City of Portland, Maine – Building or Use Permit Application 389 Congress Street, 04101, Tel: (207) 874-8703, FAX: 874-8716

LAND USE - ZONING REPORT

REASON FOR PERMIT: install free standing sign

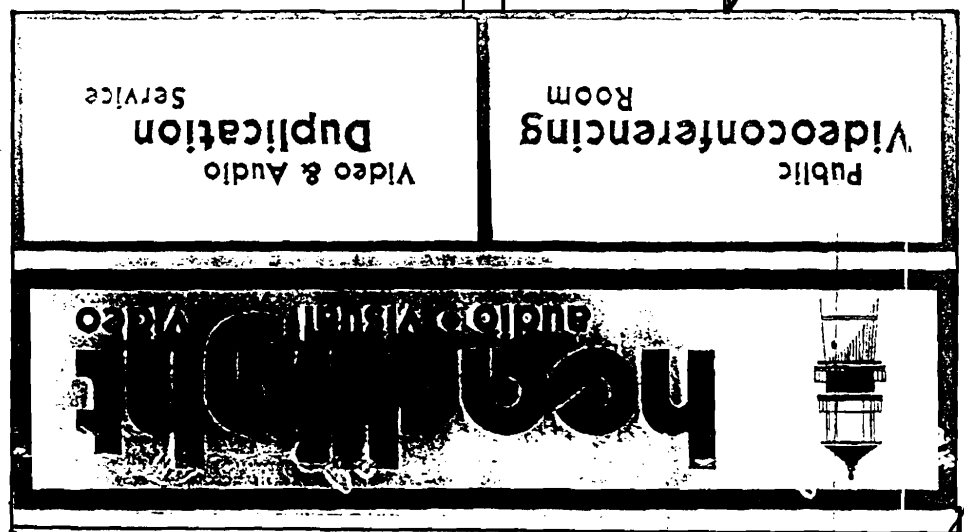
Free Standing, frontage < 200', height 65# max 18' MAX setback 5' min

shown 32# 13' shown ? not clear

MAX This to Reg to be 5'

9. Other requirements of condition The sign shall be a minimum of 5' from the property lot lines.
